Re: Dunkin Drive-Through
9700 Central Avenue SW
HT#K09D054

Kenig, Lindgren, O'Hara, Aboona, Inc. (KLOA, Inc.) has received the City of Albuquerque's comments in the March 11, 2024 letter regarding the above-referenced development. Below are our responses to the comments.

Included for your continued review are the revised Traffic Impact Study prepared by KLOA, Inc. dated May 22, 2024. Should you have any questions or require further information, please let me know.

Site Plan

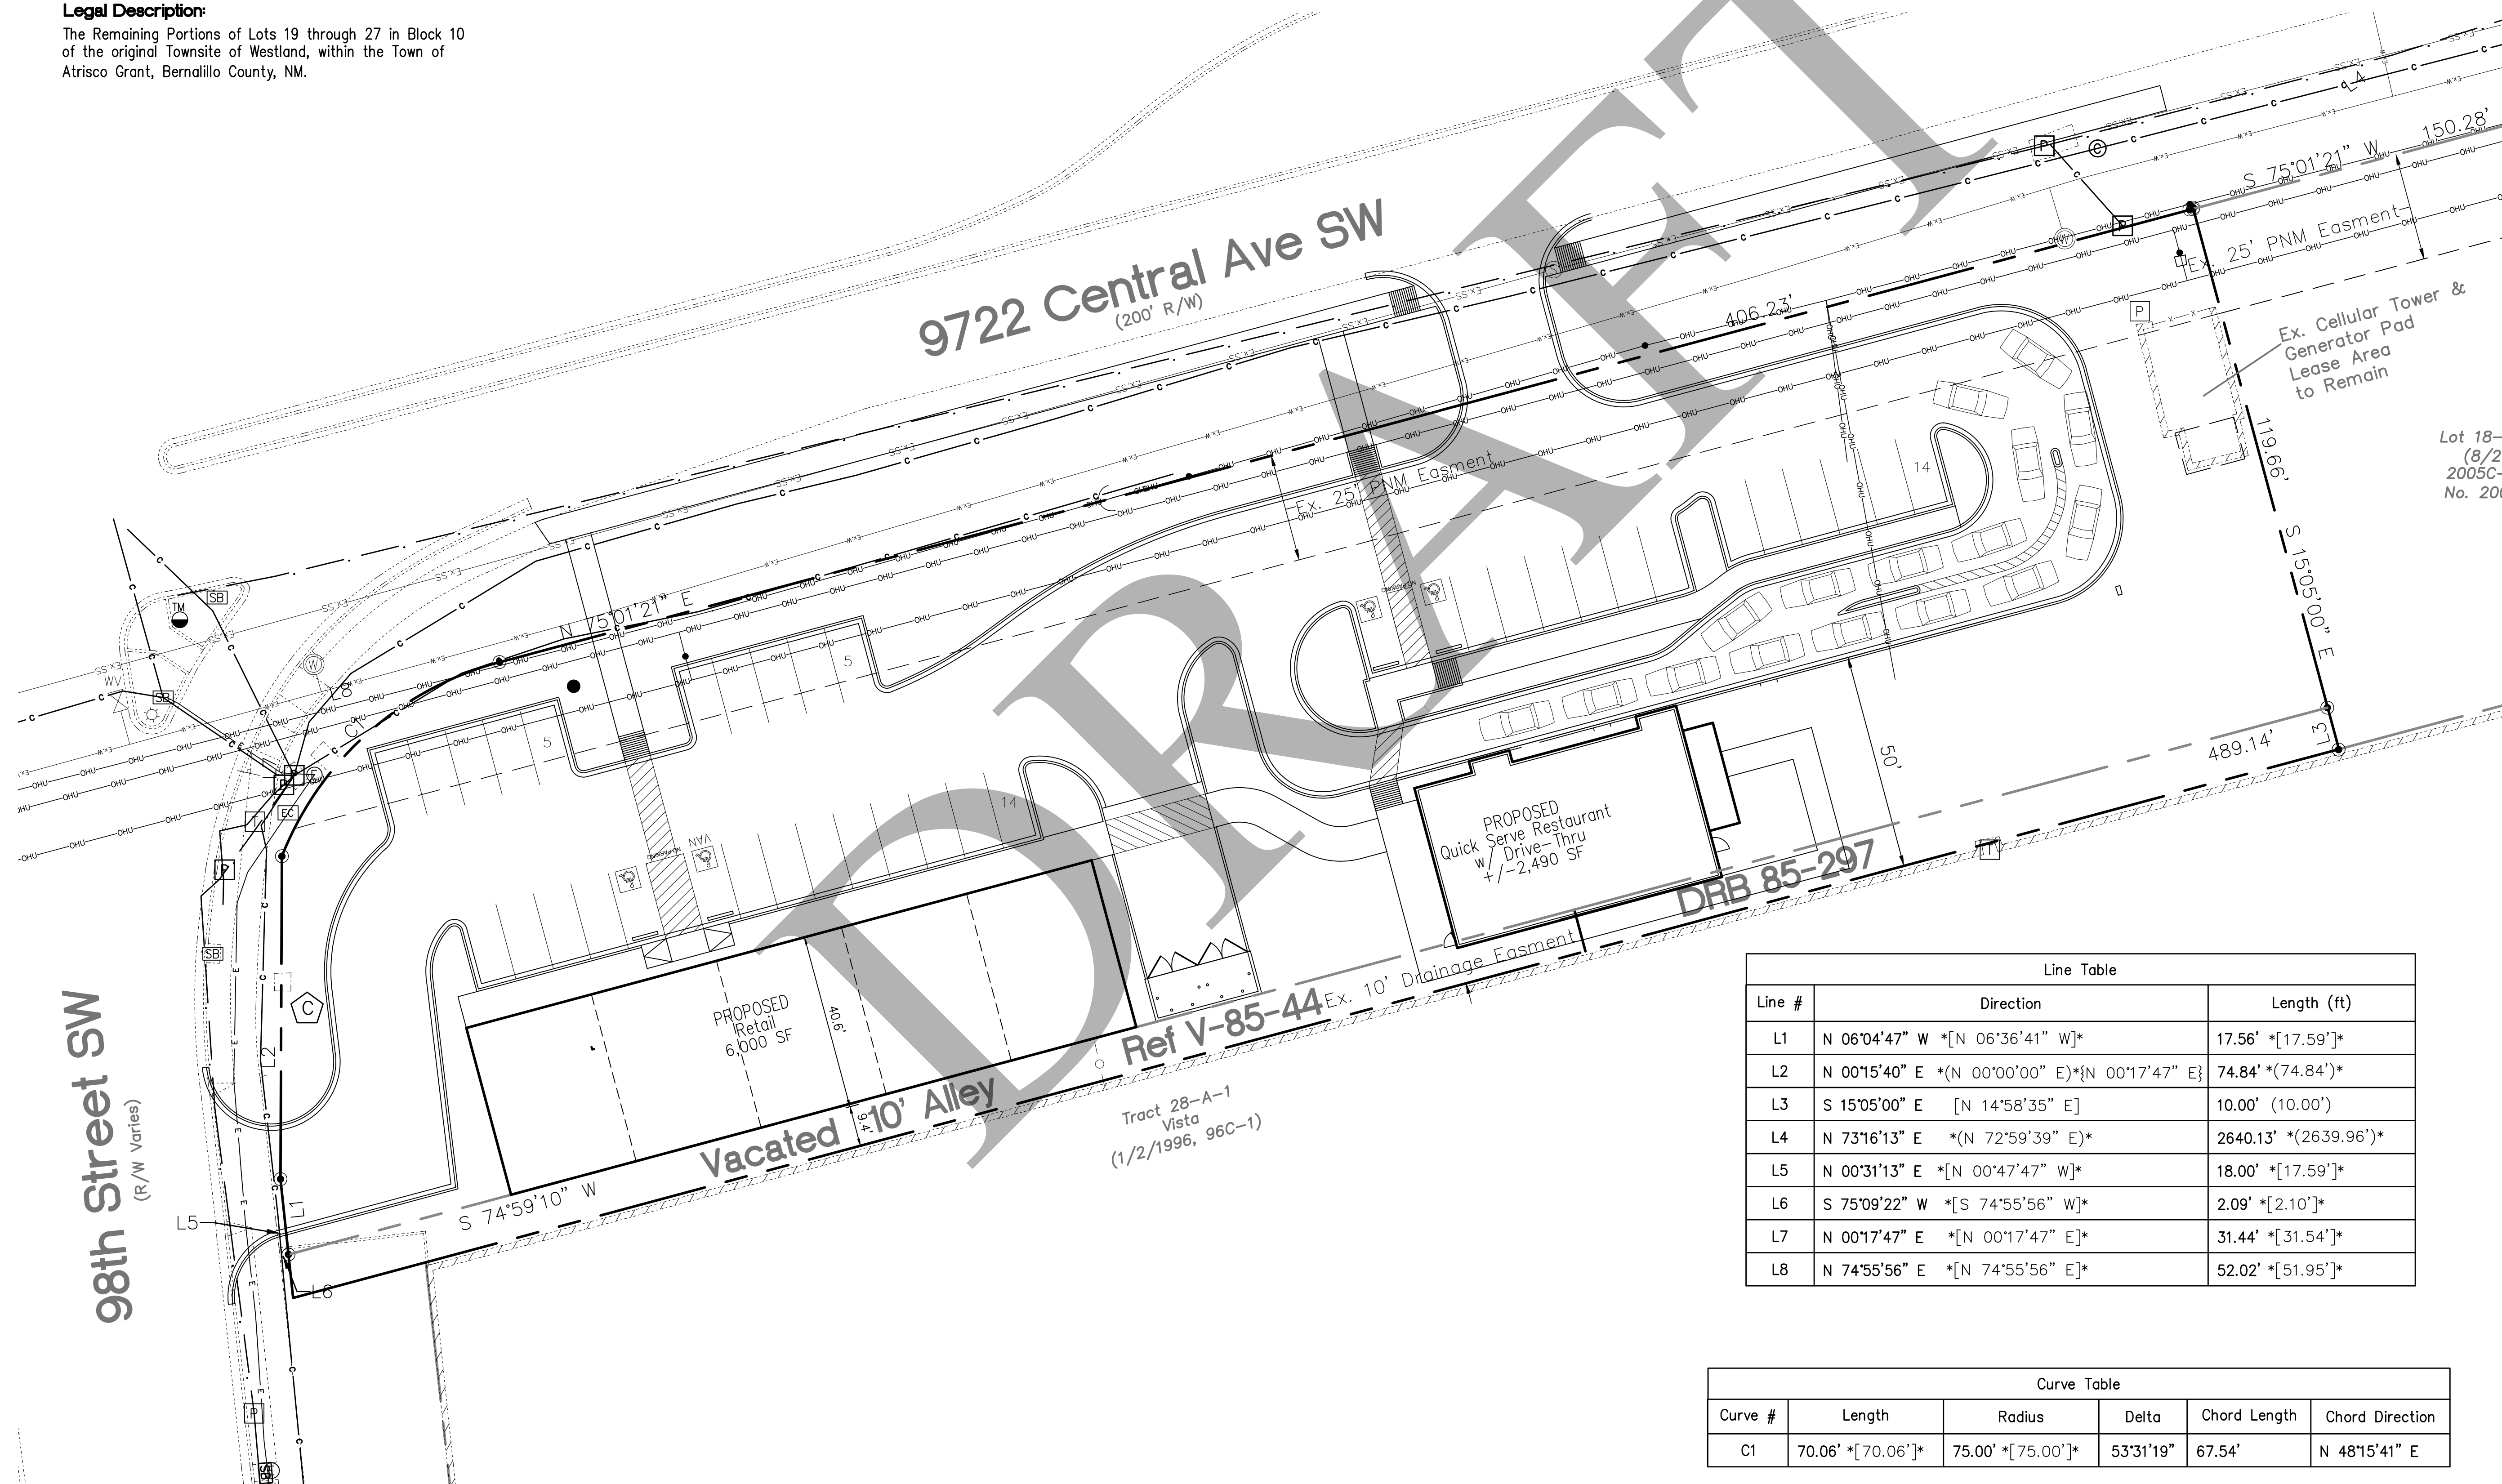
1. A proposed driveway on 98th St. is located too near the intersection of Central Ave. and 98th St. The City's Development Process Manual (DPM) in Table 7.4.54 Minimum Distance Between Commercial Site Access and Intersection requires the access distance to be a minimum of 300 feet from the approach of the intersection. The existing driveway on 98th St. is approximately 125' south of Central Ave. Correction is needed in the report on page 11 where it claims that the existing driveway on 98th St. is 175' south of Central Ave.

2. The existing auxiliary right-turn lane length is deficient in length. The COA DPM section 7- 4(I)(7)(iii)(d) Right-turn Lane Design defines the minimum turn lane lengths in Table 7.4.68 Right- turn Lane design Criteria. A right-turn lane at this location should be at least 350 feet long with 600'-300' reverse Curve transition. The exiting turn lane length is approximately 240' with no transition.

3. The proposed access on 98th St. is located within the existing northbound right-turn lane approximately centered in the auxiliary turn lane. Driveway access within a turn lane is not a normally acceptable condition. The TIS indicates in the Crash Data section of the report that the highest contributing factor for crashes at this intersection is due to Driver Inattention. Locating an access point within a turn lane under these conditions is unacceptable due to the location of the access mid-way of a turn lane and apparent poor safety history.

The access on 98th Street has been revised to reflect a right-turn in only access drive which was a preliminarily accepted as part of a meeting held on April 18, 2024.

Per the April 18, 2024 meeting, the site access has been modified to mitigate the impact of providing access via 98th Street by restricting access to right-ins only and the access drive has been designed to allow on-site deceleration.

Per the April 18, 2024 meeting, the site access has been modified to mitigate the impact of providing access via 98th Street by restricting access to right-ins only and the access drive has been designed to allow on-site deceleration.
